DOC18/671860

WestConnex M4-M5 Link (SSI 7485) Modification 1

I refer to the Department of Planning and Environment's (DPE) notice of exhibition for Roads and Maritime Services (RMS) modification application for WestConnex M4-M5 Link (SSI 7485) Modification 1.

Figure 4-5 Proposed spoil haulage routes

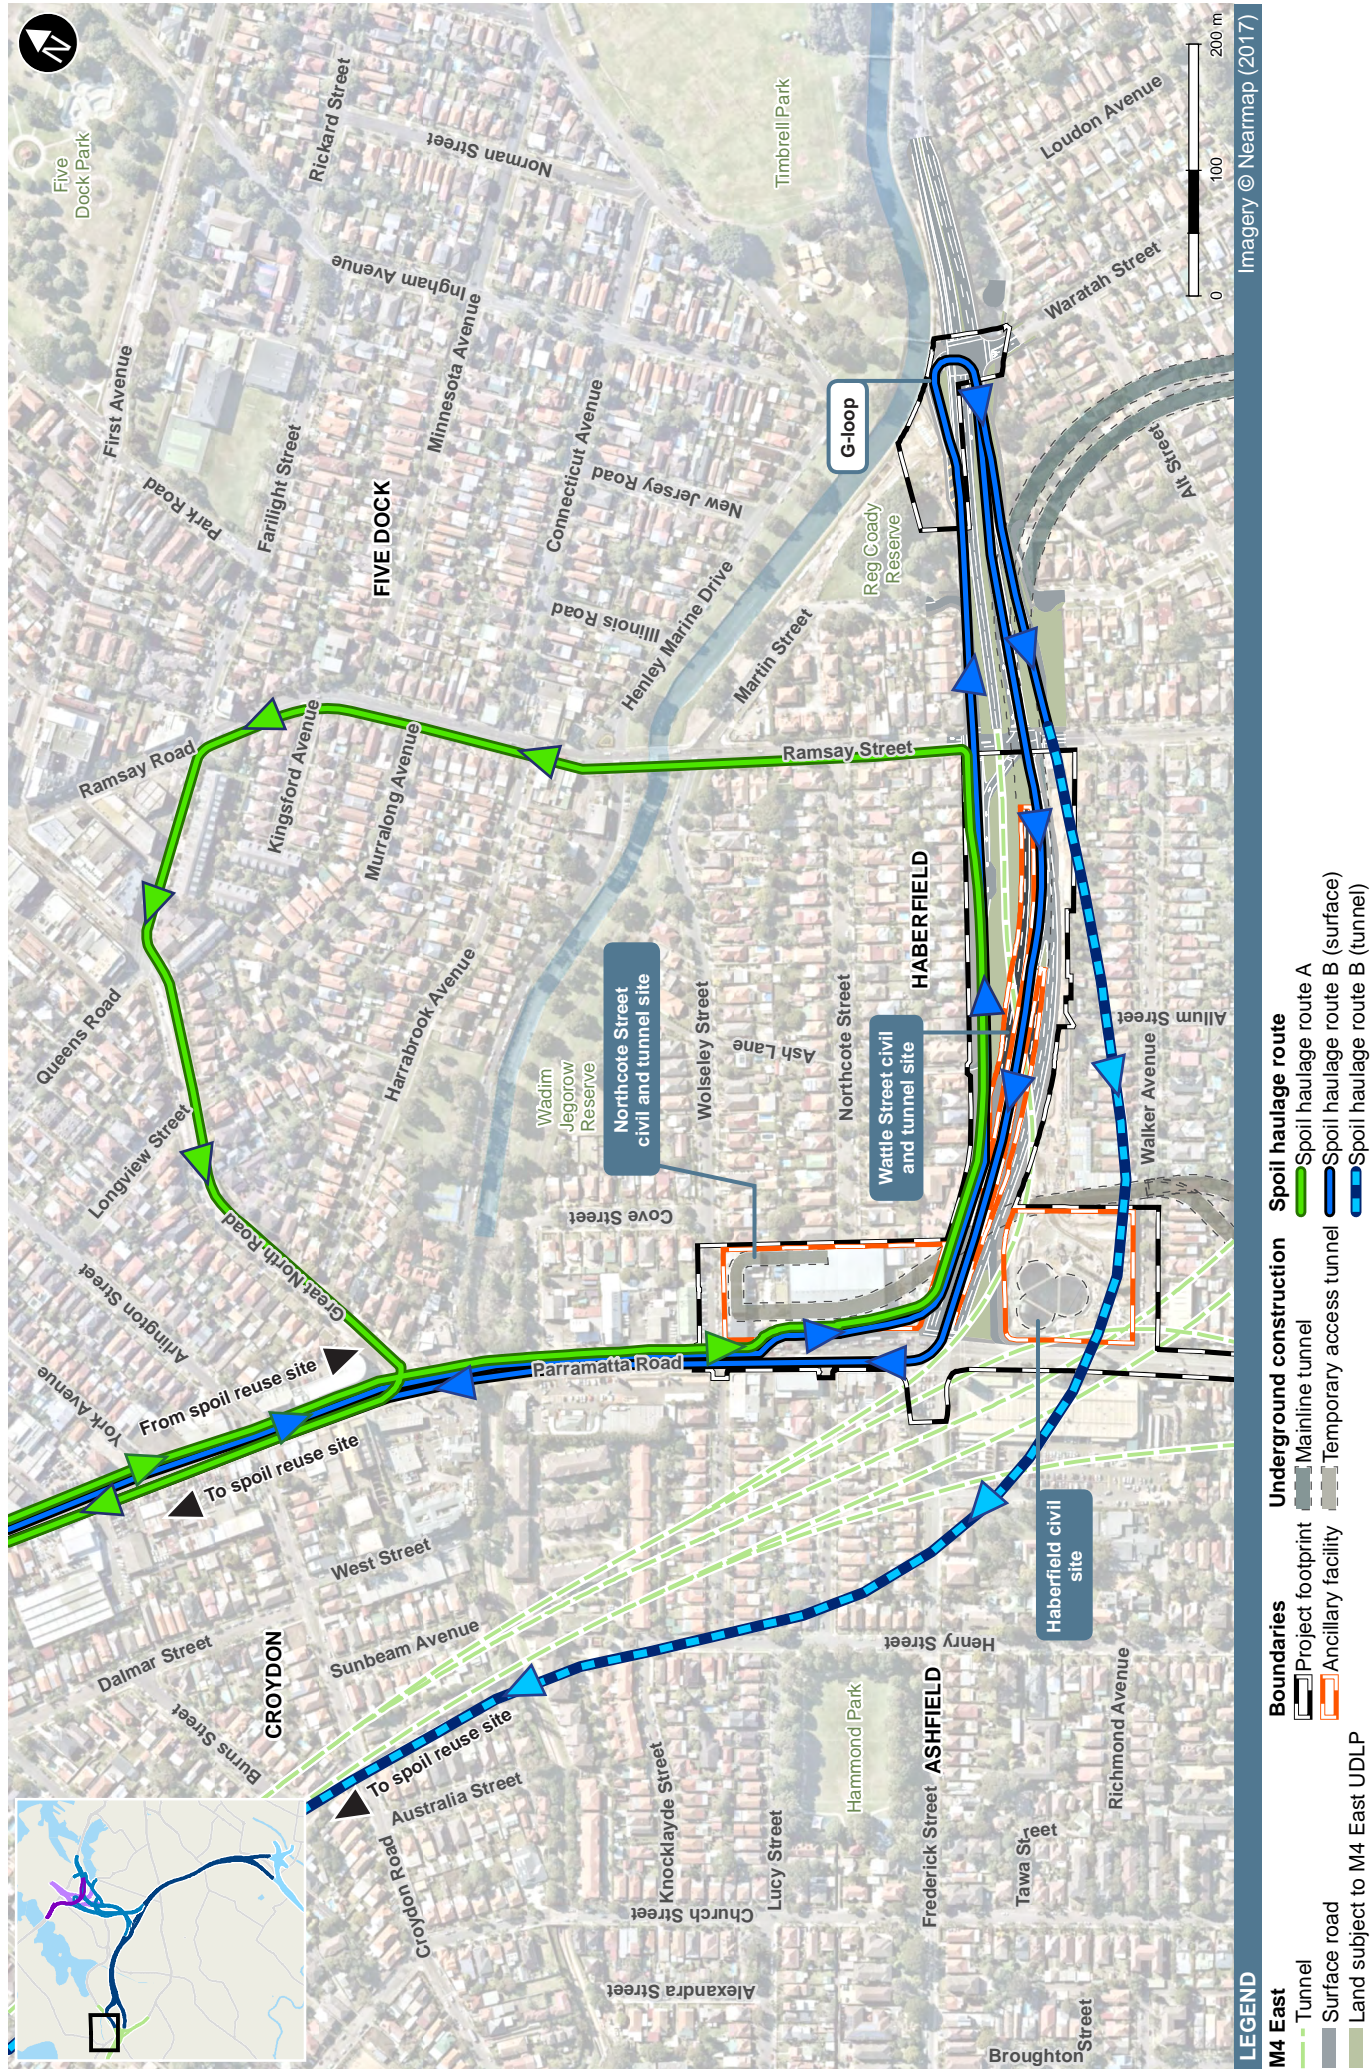
- To minimise noise impacts on residents, spoil trucks from the Northcote St site should preferably use the Wattle St and "G loop" route (Route B) and then the M4 East tunnel at all times. If this is not possible due to significant impacts on peak hour traffic flows on Wattle St/Dobroyd Parade from G loop operation, then use of Route A (Ramsey St/Fairlight St) could be considered at these times. The EPA considers that this route should not be used during evenings or night periods (ie 7pm to 7am).

Figure 4-8 Indicative Campbell Road motorway operations complex layout including proposed water treatment plant

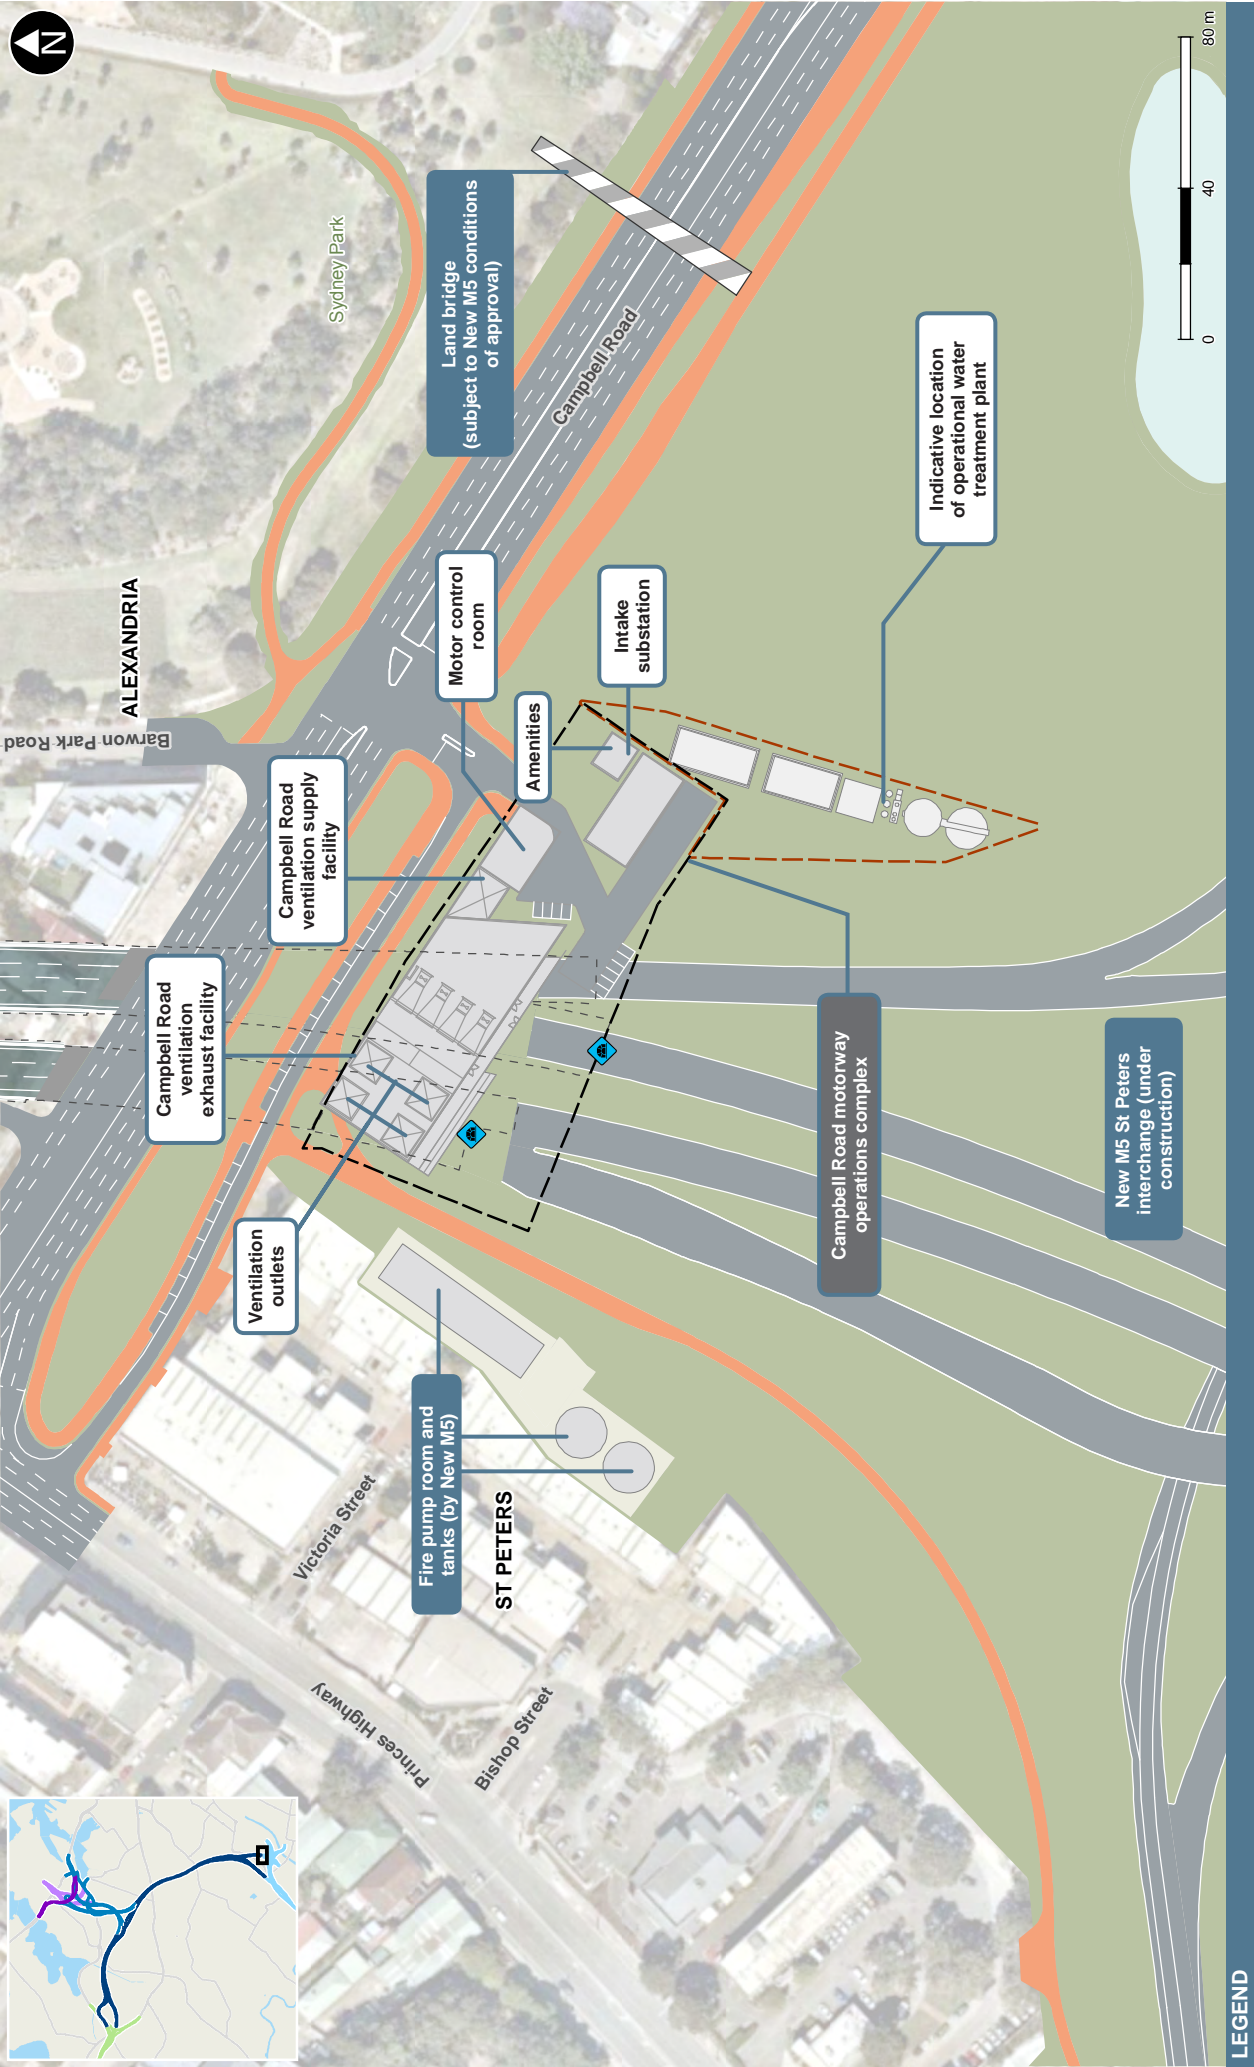
- RMS should consider whether the operational water treatment plant proposed to be relocated to the St Peters interchange site requires an environment protection licence under the *Protection of the Environment Operations Act 1997* for contaminated groundwater treatment. Given the St Peters interchange site is a former landfill, there is potential for groundwater contamination in this area. RMS should note that the criteria for a contaminated groundwater treatment licence relates to the concentration of pollutants in the inflow to the treatment plant.
